PREFERRED PROJECT REPORT
MP 10_0171

330 CHURCH STREET, PARRAMATTA

JULY 2012

SHADOW DIAGRAM - WINTER SOLSTICE (JUNE 21ST) 3.00PM
1:2000 @ A1

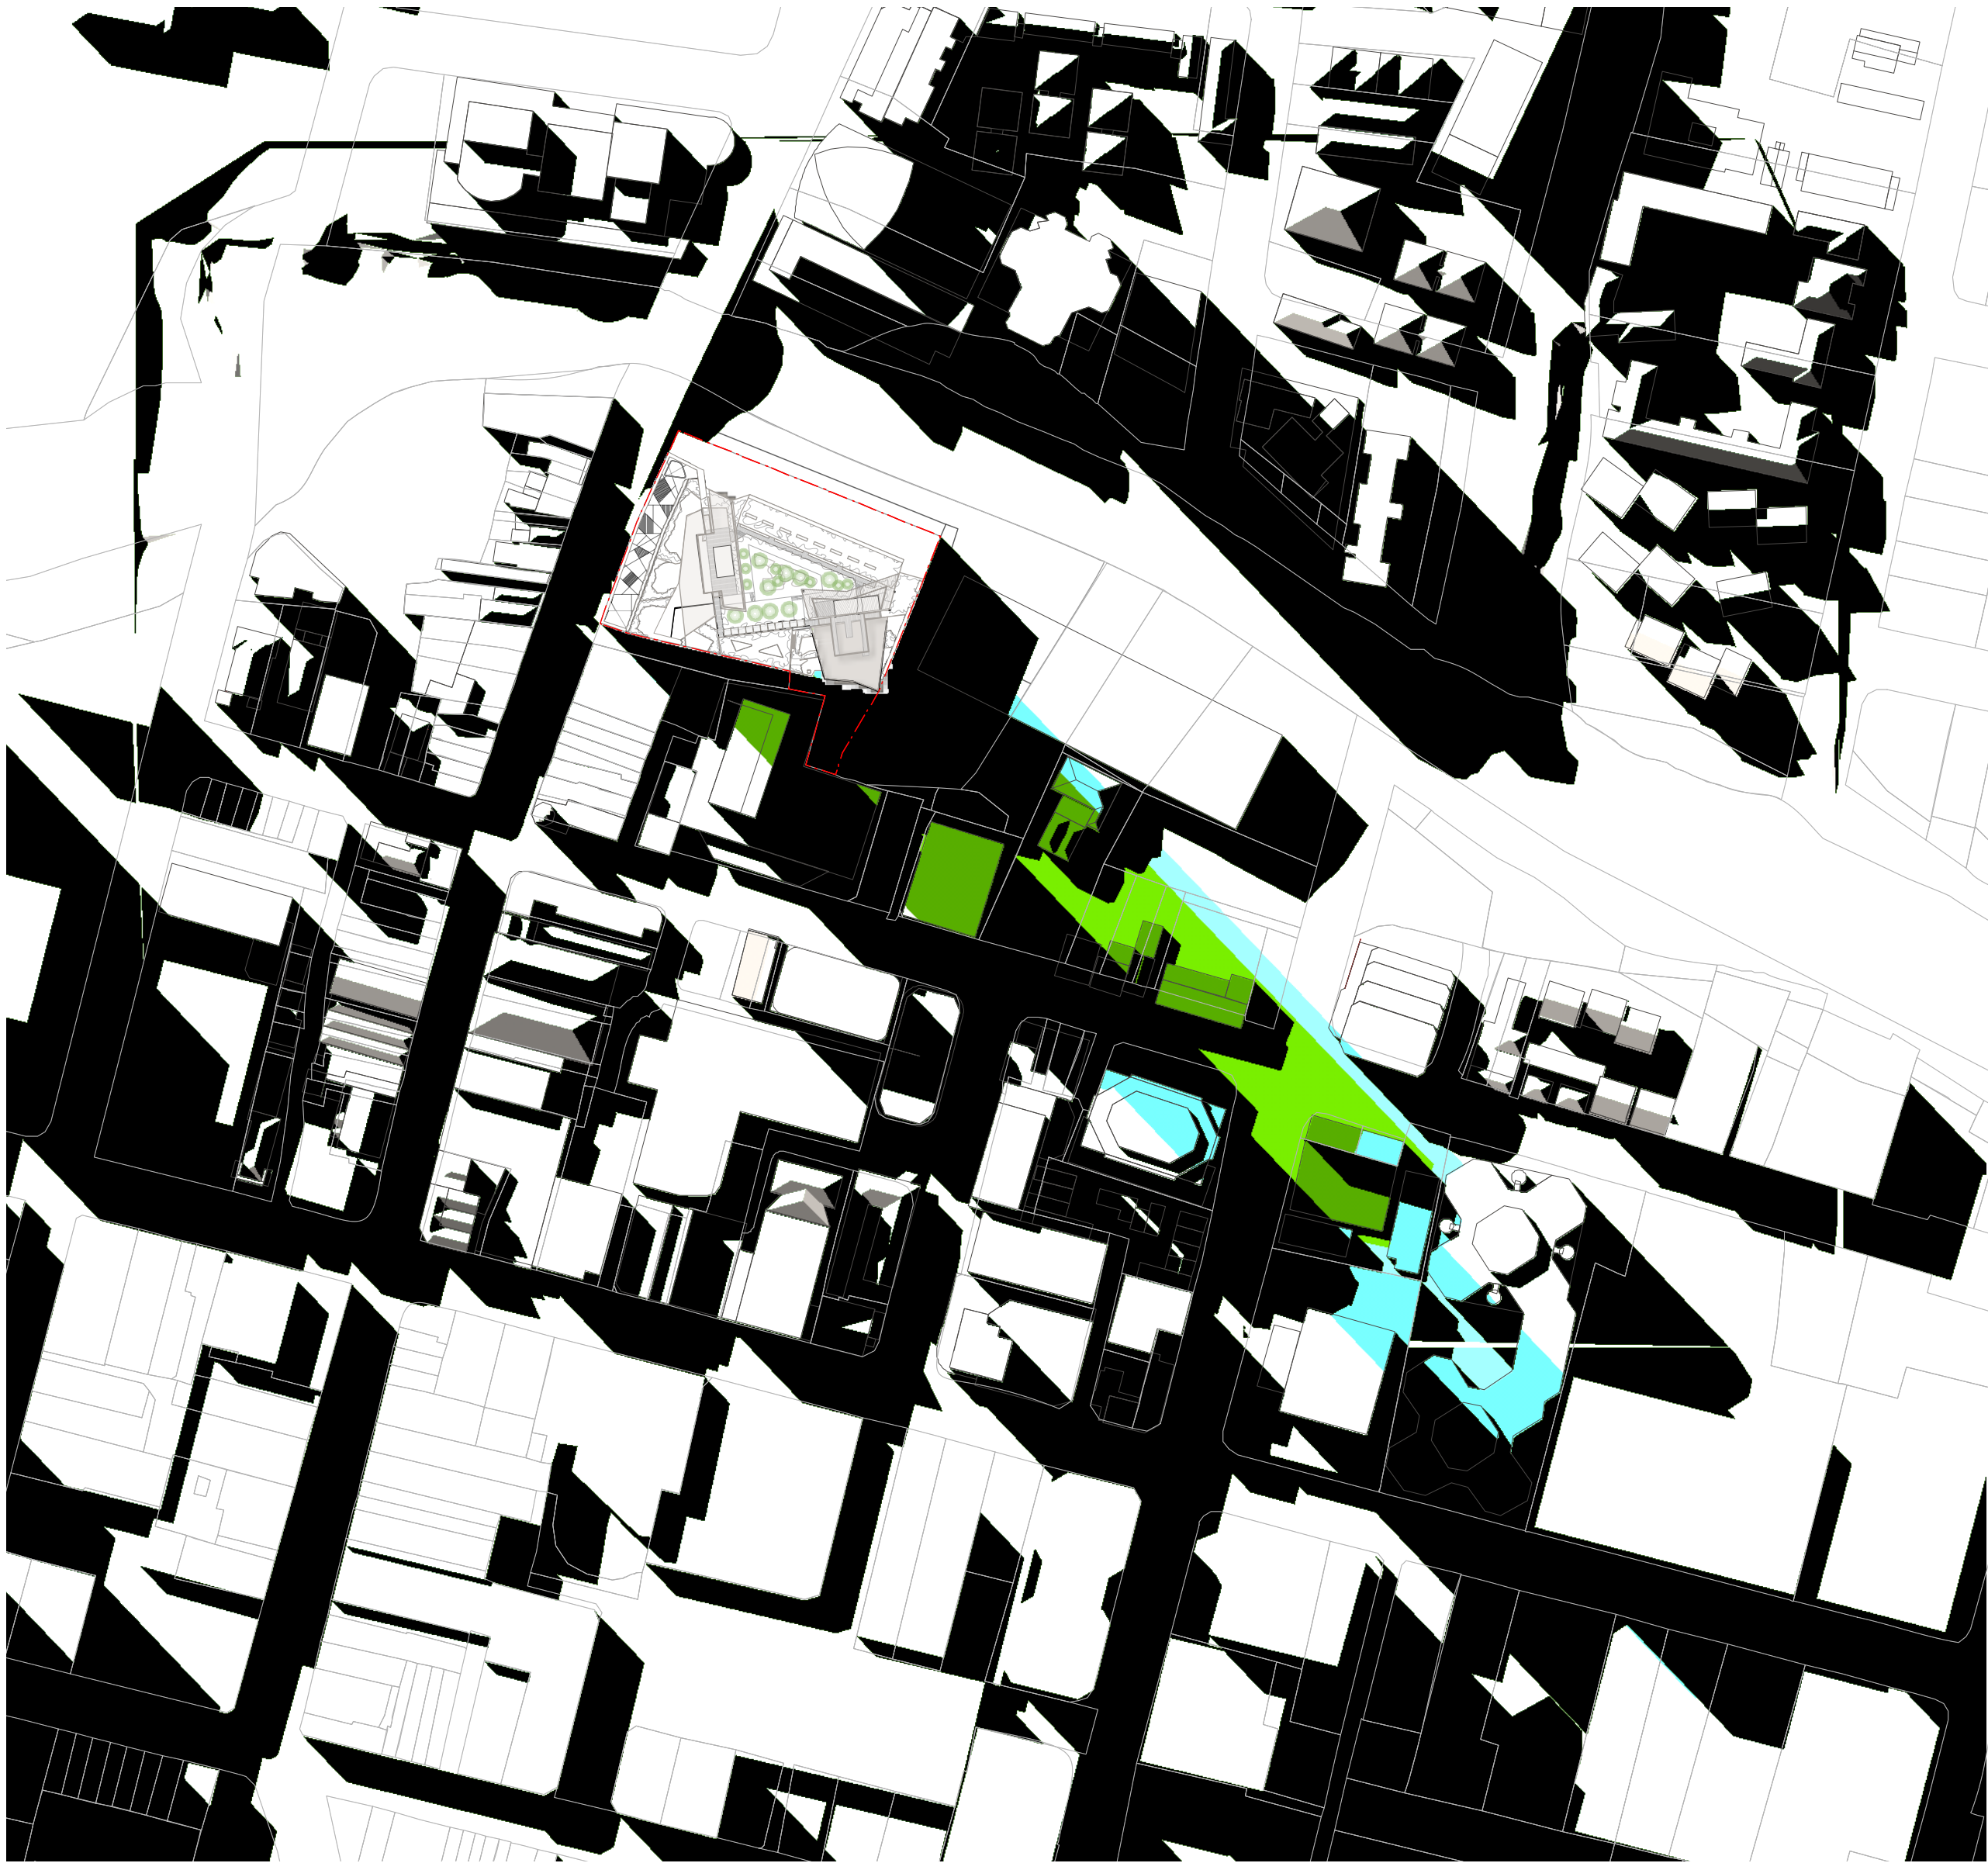
Shadow Diagrams

The architectural plans have been amended to include shadow diagrams providing a comparison between the existing building, a compliant development (built to the current height maximum and incorporating the setbacks specified in the Riverbank Site Controls) and the proposed development. This is now shown on plan A500 and A501. The amended architectural plans are at Annexure 3.
